APPLICANT'S RESPONSES TO ISSUES RAISED AT DEADLINE 6

Drax Bioenergy with Carbon Capture and Storage

Document Reference Number: 8.10.6

Applicant: Drax Power Limited

Drawing file: published-documents / EN010120-000178-6.2.6.8 Drax BECCS ES Vol 2 Figure 6.8 Annual Mean Nitrosamines Maximum Contribution (Baseline).pdf

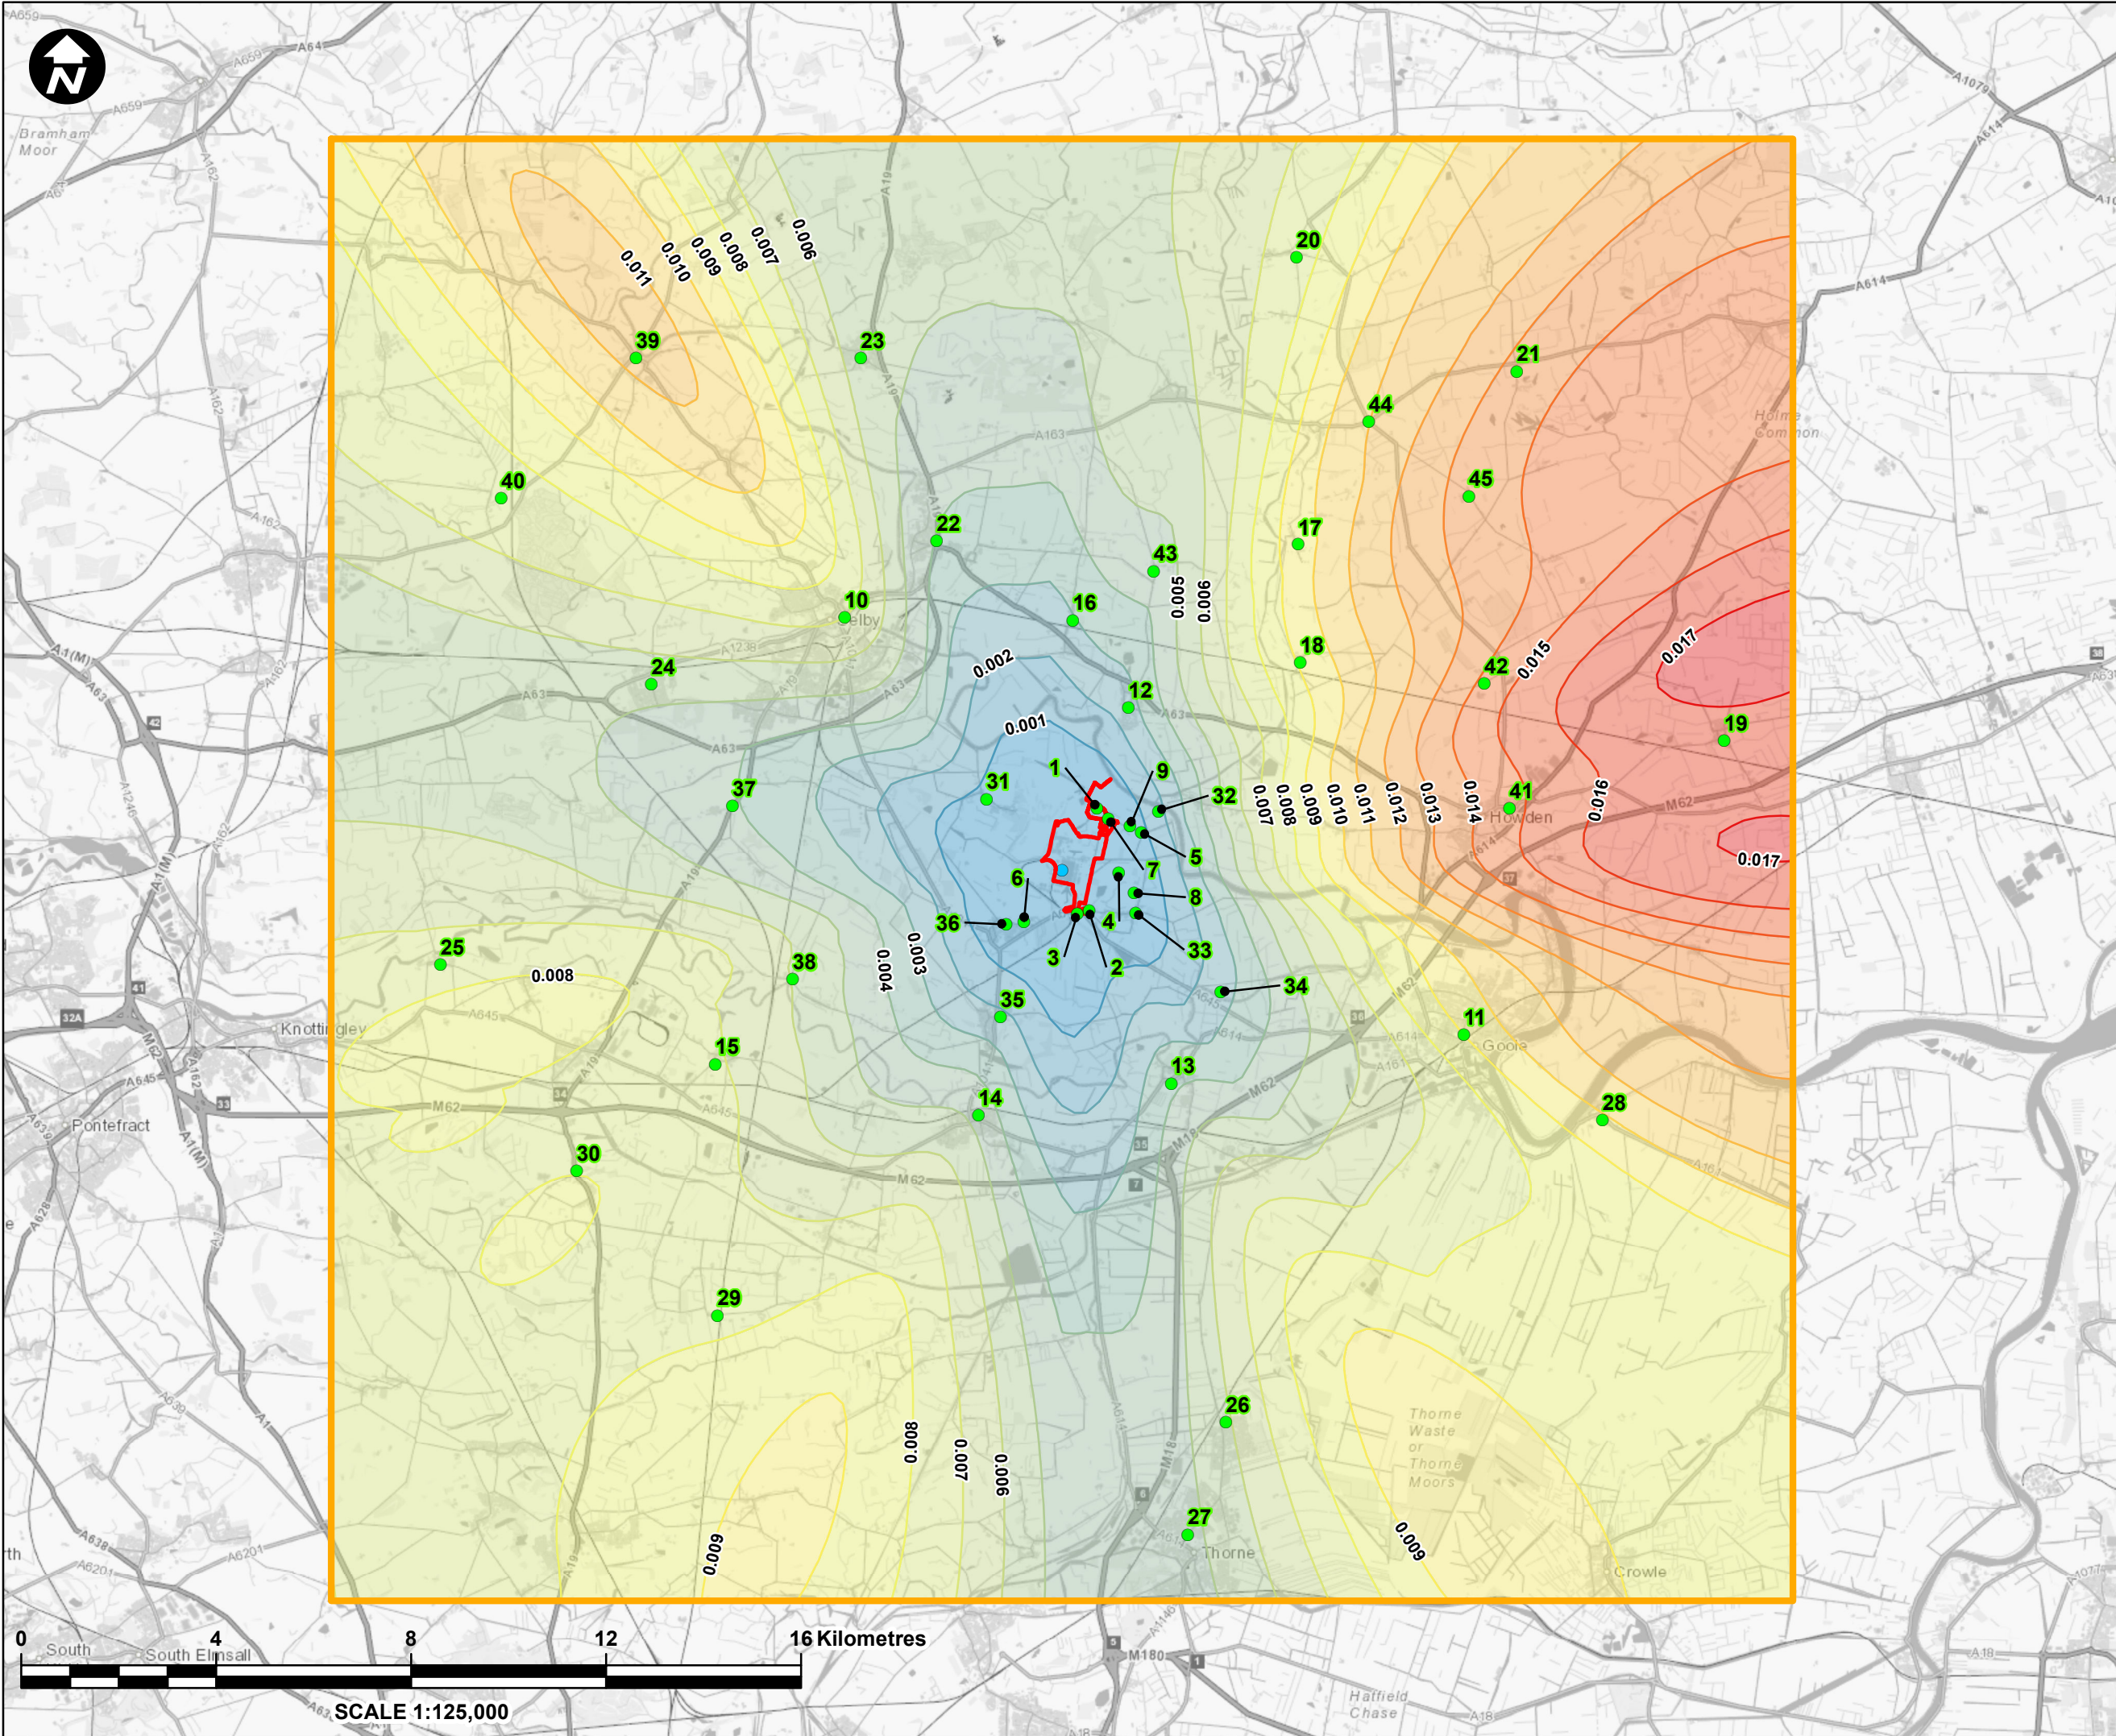
Response Ref.	Comment (including location in original submission)	Applicant's Response
5.1	<p>REP2-073 para 57, REP4-020 ref 9.8</p> <p>The applicant's response, which refers to EA Guidance, does not address the concern that the location with the largest nitrosamine concentrations may not even be on figure 6.8 [APP-075]. Biofuelwatch notes that the Environment Agency was unable to confirm whether the applicant's approach is correct in their response to the ExA's questions (AQ.1.4 of [REP2-076]). The applicant's response says photolytic degradation of the nitrosamines has not been taken into account in the amine chemistry modelling, which will lead to overestimation of pollutant concentrations at distance from the stack. Any such overestimation may, however, not be significant at this geographical scale because of the stability of nitrosamines in the atmosphere (see paragraph 72 of Biofuelwatch's deadline 2 submission [REP2-073]) and because photolytic degradation requires sunlight (and therefore will not occur at night and will be greatly reduced when the sun is obscured by clouds). Biofuelwatch also notes the applicant did not comment on the findings of the Norwegian Institute for Air Research and the Norwegian Institute for Water Research (in collaboration with the Norwegian Institute of Health and others) that reported</p>	<p>The Applicant notes that Figure 6.8 (Annual Mean Amines Nitrosamines Maximum Contribution (With Proposed Scheme - Baseline) (APP-075) shows the total concentration of nitrosamines plus nitramines resulting from the Proposed Scheme.</p> <p>The maximum impact from nitrosamines is indeed contained within the figure and occurs between 13 and 15km from the power station.</p> <p>The maximum impact from nitramines, as modelled, occurs slightly further from the stack and at the edge of the modelled study area but is also appropriately represented with the 15 x 15km study area, since this extends some 21km downwind of the power station on the prevailing wind direction (i.e. the distance from the stack to the north-east corner of the study area is over 21km).</p> <p>Therefore, whilst the maximum modelled concentration of nitrosamines plus nitramines occurs close to the edge of the modelled study area, it is indeed captured within it.</p> <p>Furthermore, as explained previously, the assumptions inherent within the modelling of impacts become increasingly conservative with distance from the stack.</p>

Response Ref.	Comment (including location in original submission)	Applicant's Response
	<p>significant nitrosamine concentrations over considerable distances (considered in paragraph 68 of Biofuelwatch's deadline 2 submission).</p> <p>Biofuelwatch requests that the ExA requires the applicant to carry out modelling that shows, beyond doubt, the location with the predicted highest nitrosamine concentration together with one or more supporting diagrams to show the full extent of the geographical spread of nitrosamine concentrations. Biofuelwatch also requests diagrams showing the cumulative modelled nitrosamine impact with other consented plants to aid the assessment of cumulative impacts.</p>	<p>As such, EA and ExA can be confident that the maximum impact of nitrosamines has been conservatively assessed.</p> <p>As a final note, paragraph 68 of Biofuelwatch's deadline 2 submission states that the Norwegian Institute for Air Research and the Norwegian Institute for Water Research (in collaboration with the Norwegian Institute of Health and others) found that 'maximum hourly nitrosamines concentrations decline only slightly at distance of 10km'. The modelled study area is, as stated above, 15km x 15km and the maximum modelled nitrosamine concentrations occur at the edge of this study area. This is beyond the distance at which the Norwegian study reported slight declines in concentrations. Taking into account the Norwegian study and the conservative modelling of the Proposed Scheme, the EA and ExA can also be confident that the point of maximum ground level impacts on nitrosamines and nitramines has been captured within the study area.</p>
